Your Ref: OWPC19998
Our Ref: R/183/18/HH 01-08-2018
Please ask for:
Samantha Allen

Front ground floor extension, ridge extension to form gable w all over front extension, 2 new bedrooms & bathroom in roof space w ith dormer extension to side, 2 velux w indow s provided in existing roof slopes.

8 Acre Close Rustington

Thank you for your internet representation made on 18th September 2018 which has been recorded as '**an objection**' with the comments as follow s:

10.20m.
dormer
length.

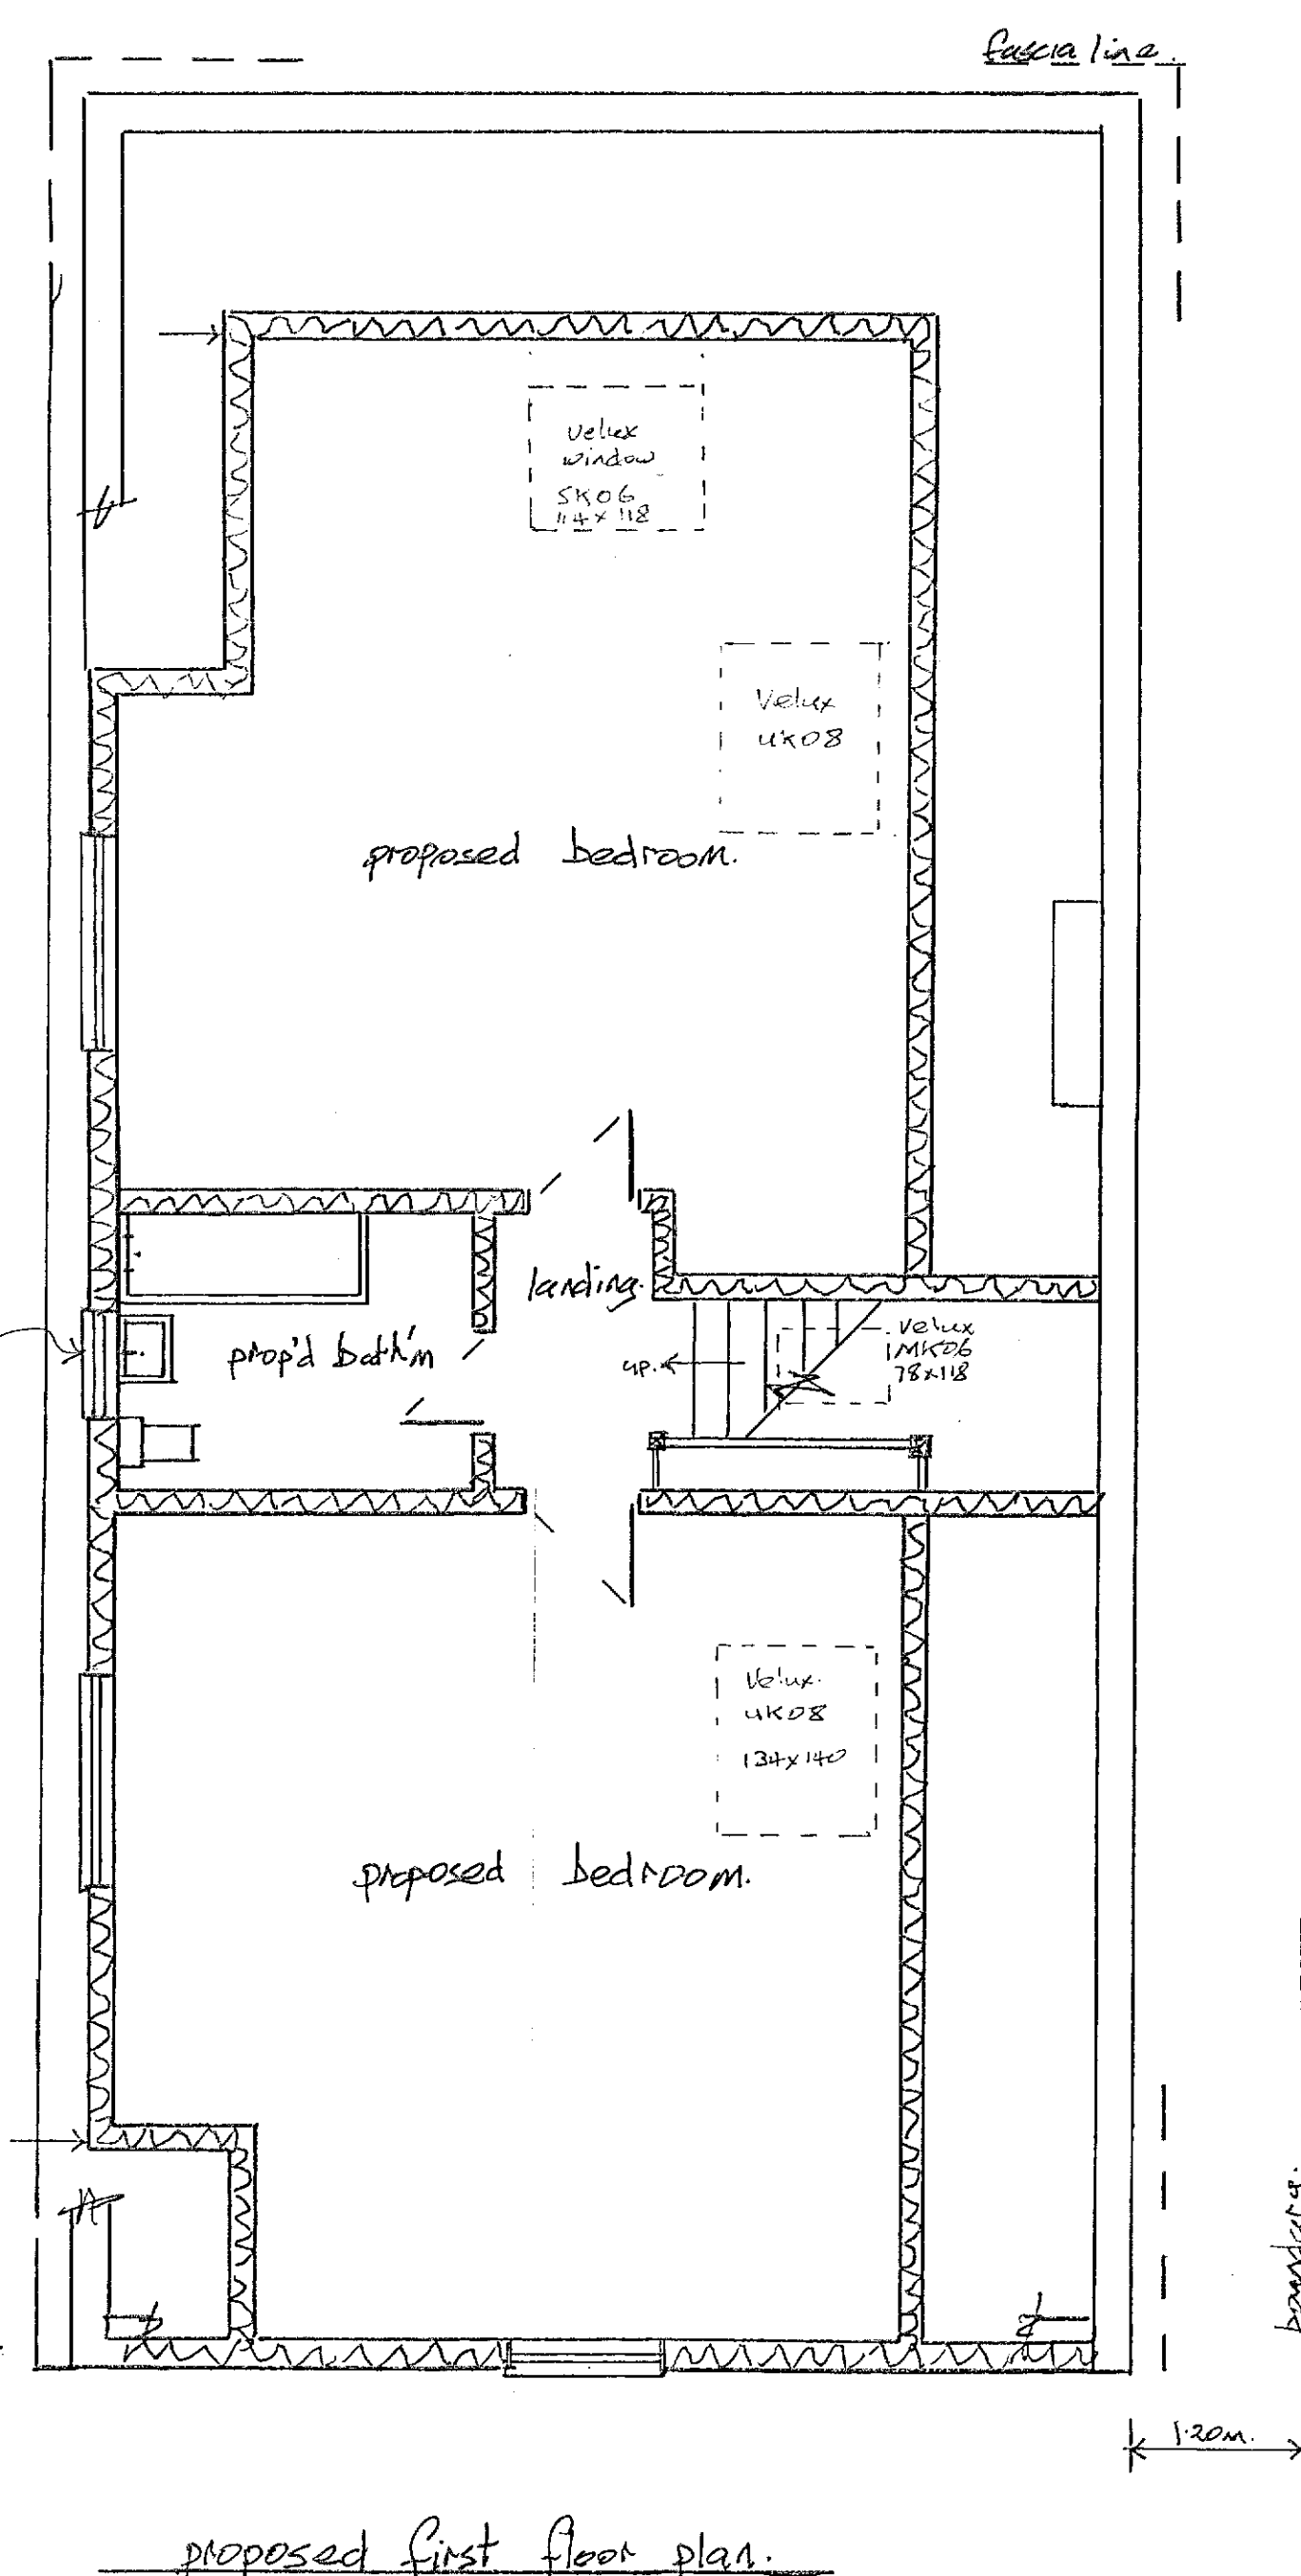
Acre Close has 10 detached traditionally built bungalows and having examined the planning drawing submitted I consider the scheme proposed for No 8 will be totally out of place and not in keeping with the adjacent buildings/surroundings. Furthermore the proposed construction of a long dormer to the east elevation complete with clear glazed windows facing over my lounge window will I suggest be an invasion of privacy.

The application states that two Velux windows are to be fitted in the existing roof structure. The drawing shows four Velux windows? Would appear each bedroom will have two Velux and one opening light window? More than adequate. Why not consider bedroom windows fitted on front and rear elevations therefore not overlooking adjacent properties
